**KIRKLEES METROPOLITAN COUNCIL
INVESTMENT & REGENERATION SERVICE**

**DELEGATED DECISION TO DETERMINE APPLICATIONS FOR
NON-MATERIAL AMENDMENTS**

Reference No: **2023/NM/91453/E**

Site Address: 48, Woodburn Avenue, Earlsheaton, Dewsbury, WF12
8LJ

REVISIONS:
A 17-05-2023 Dormer facia and side cheek finish amended to painted render.

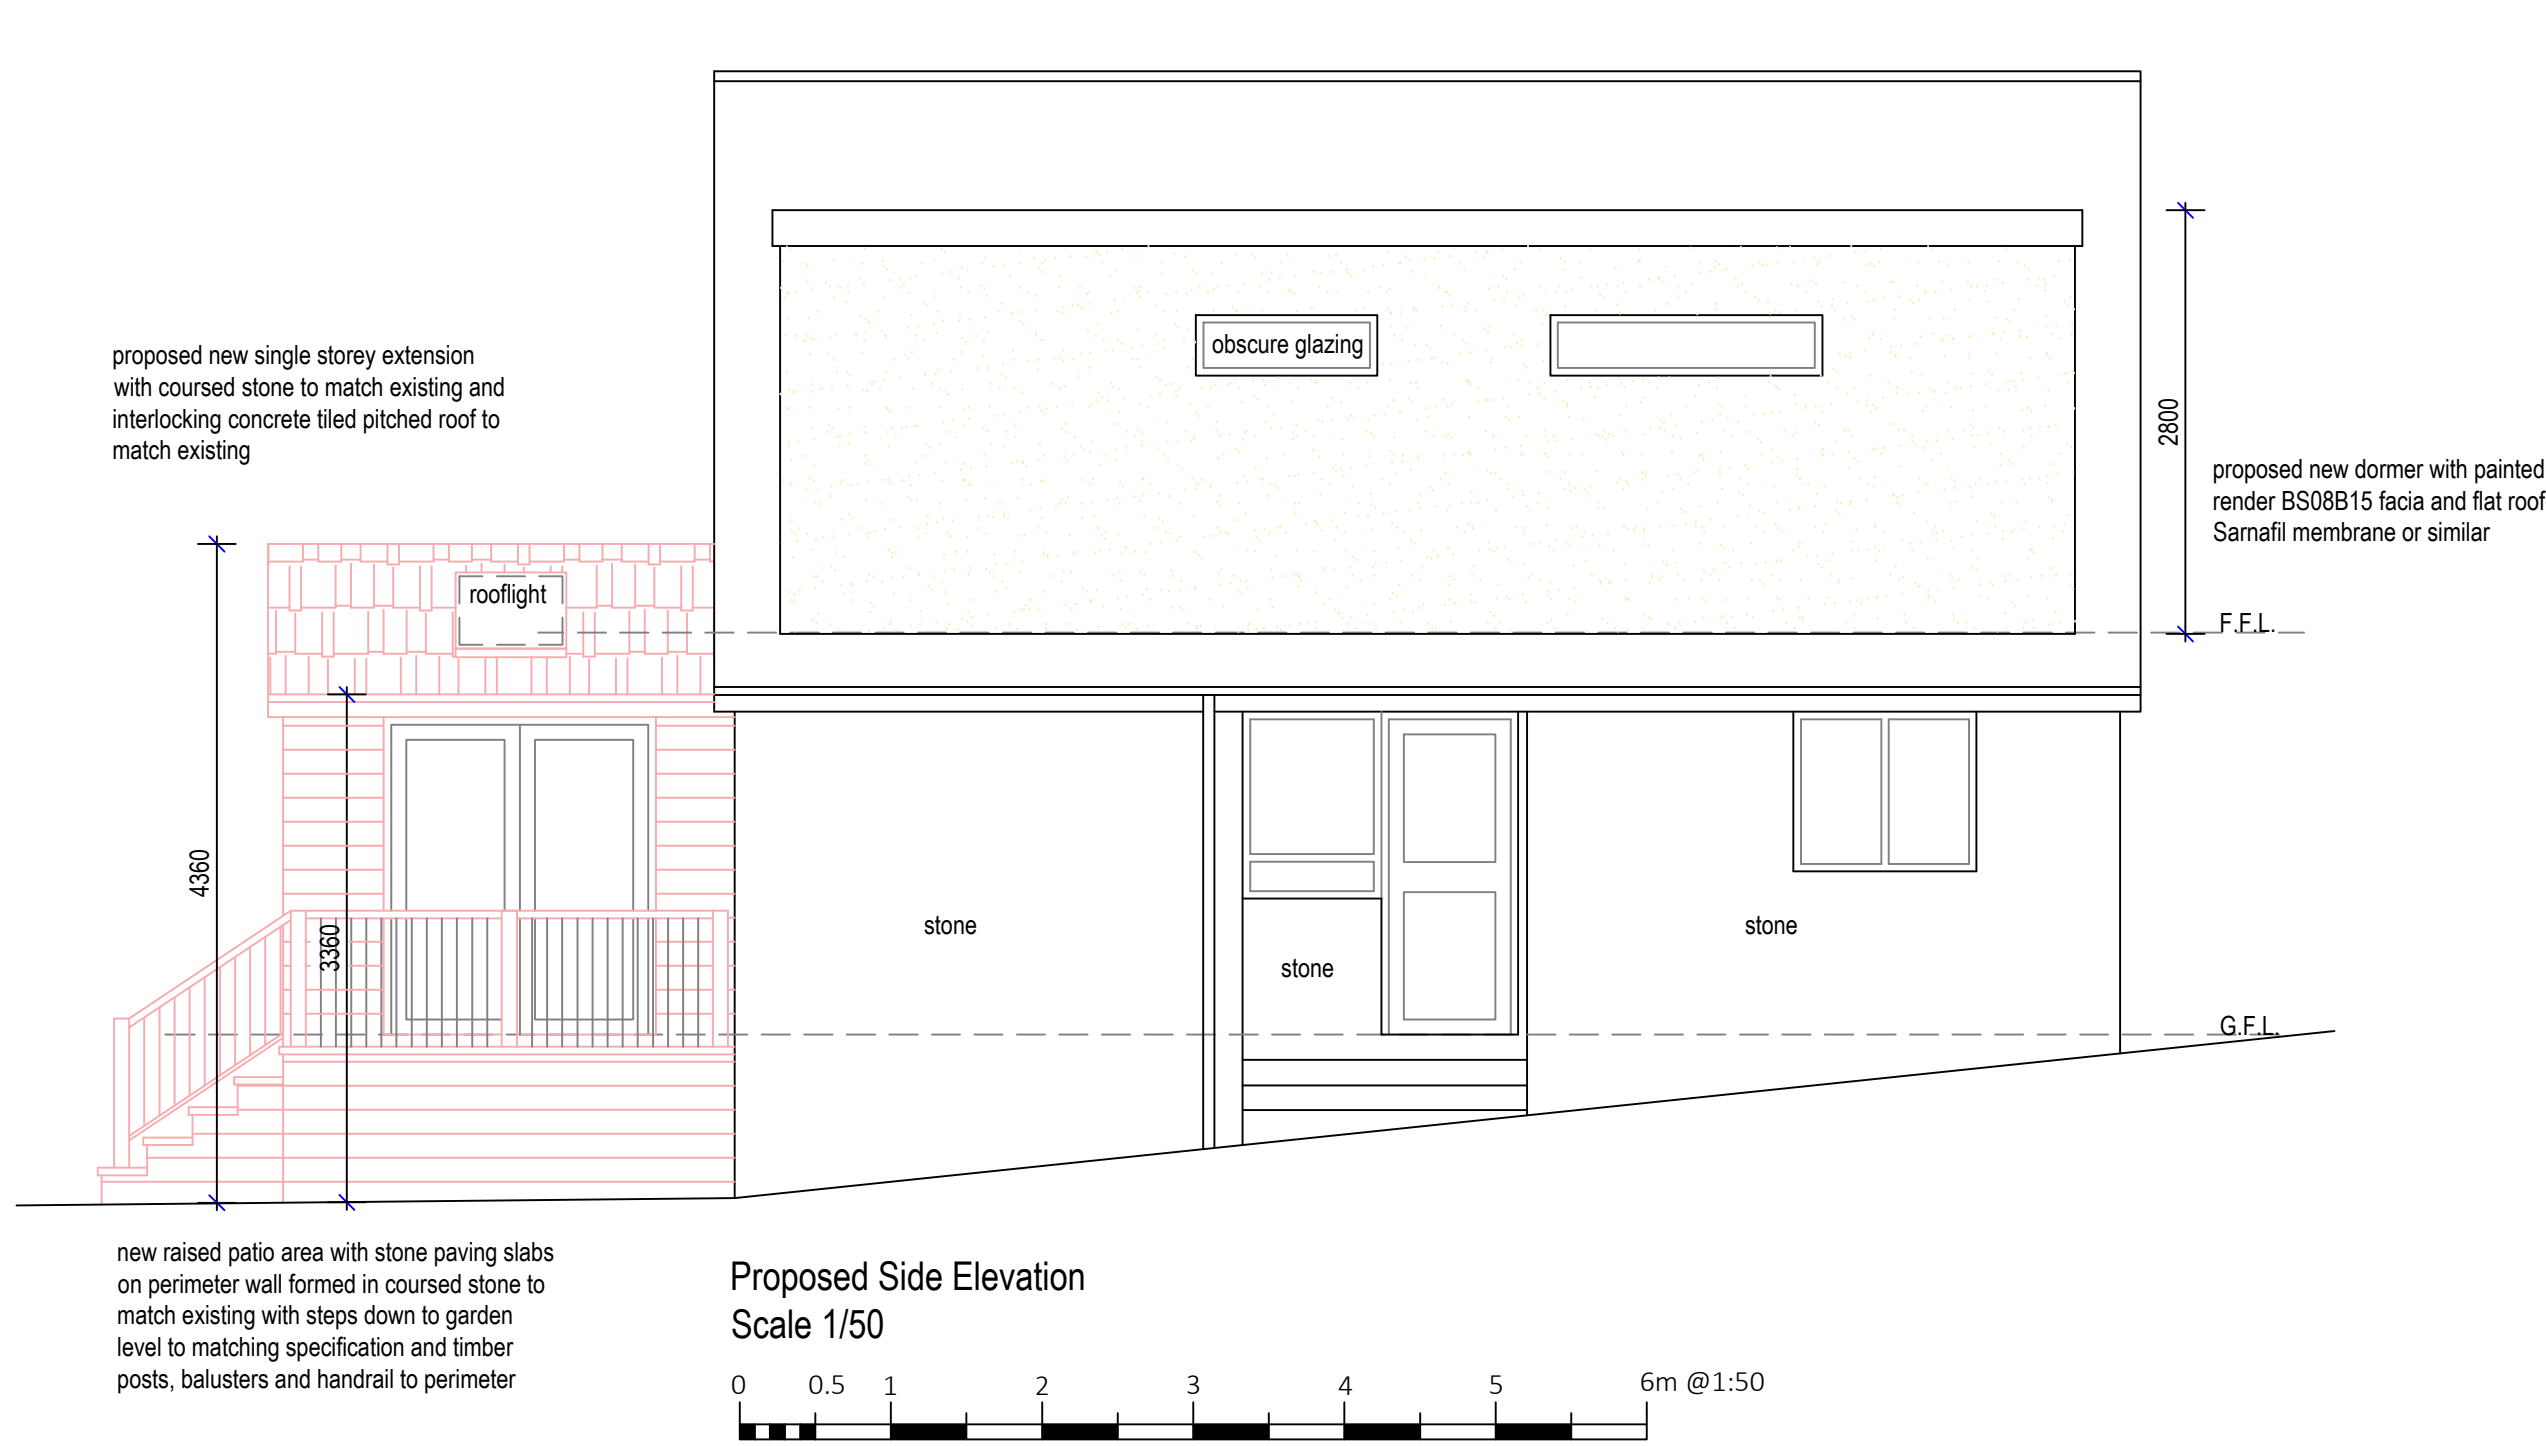
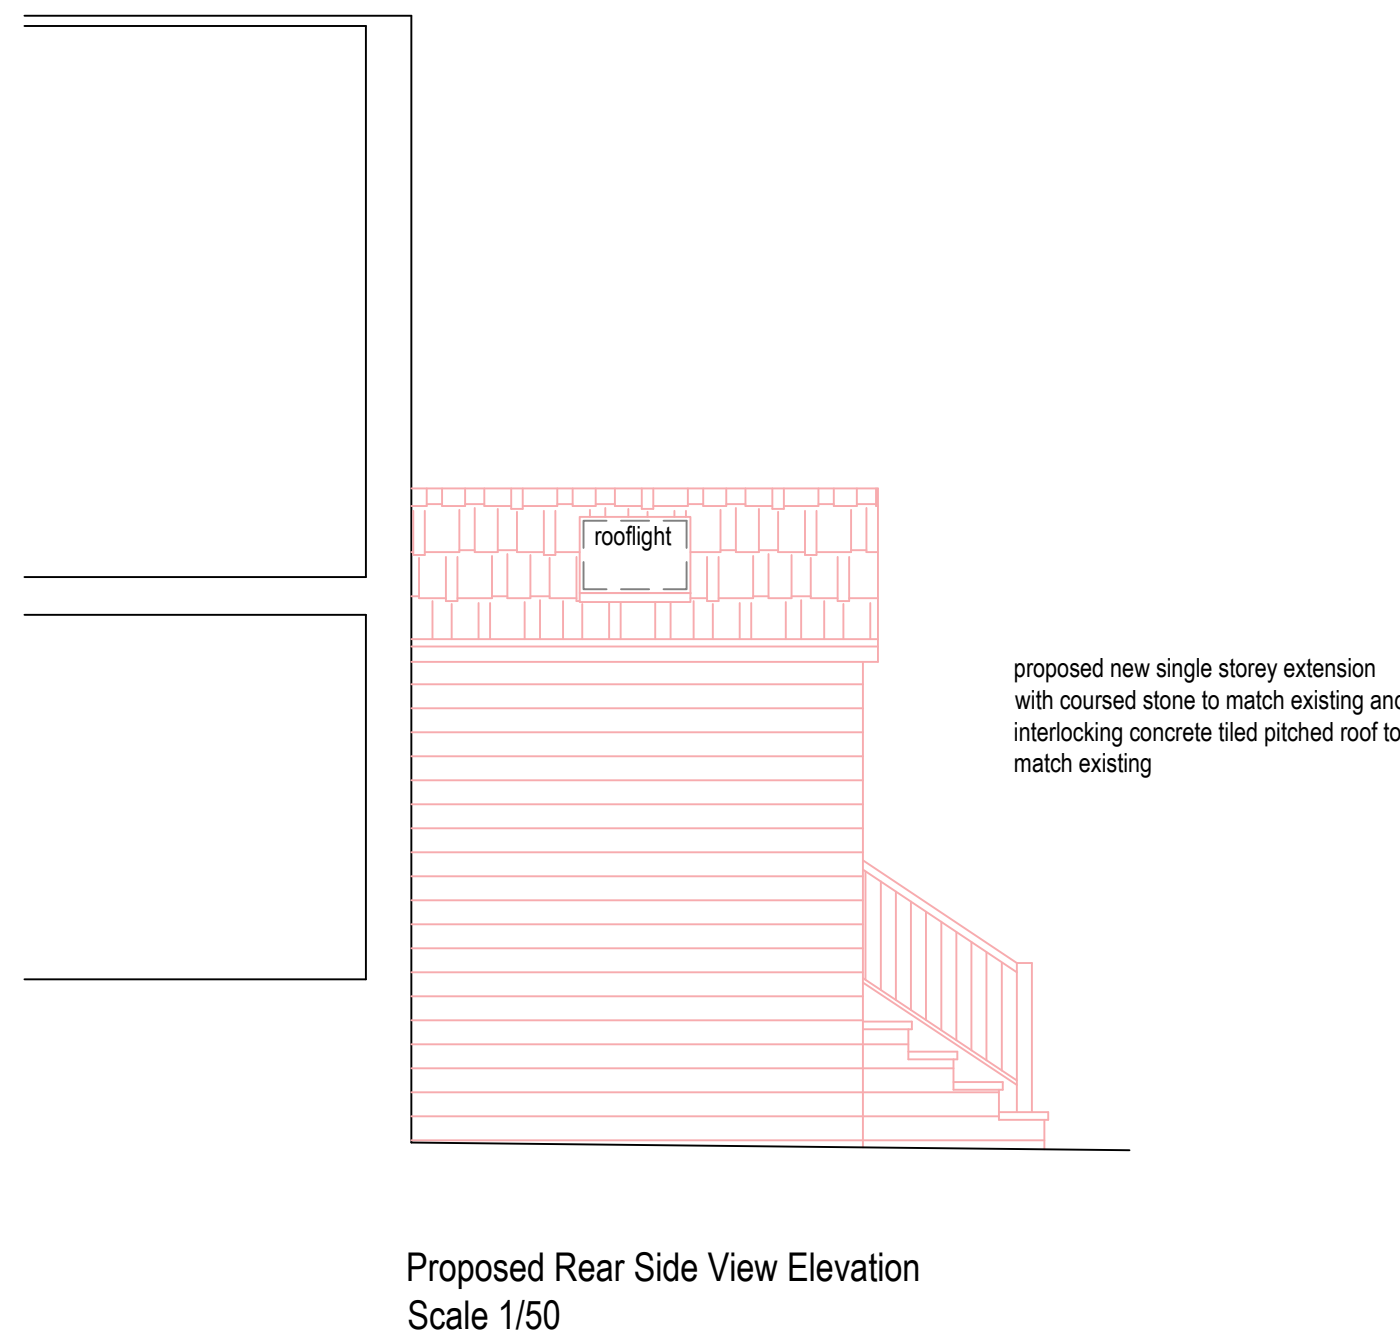
2. *Would the change result in a detrimental impact either visually or in terms of living conditions?* The proposal would amend the materials of the previously approved dormer to feature a rendered finish. There is not currently any render within the street scene and it is considered that the proposal would introduce a new material into the street scene. Therefore, it is considered that the proposal would result in detrimental impact visually.

To conclude, the amendment shown on the submitted drawing 272-01-03A to amend the proposed materials of the previously approved dormer is not

considered to be acceptable and cannot be regarded as a non-material amendment to the previous approval 2022/90937.
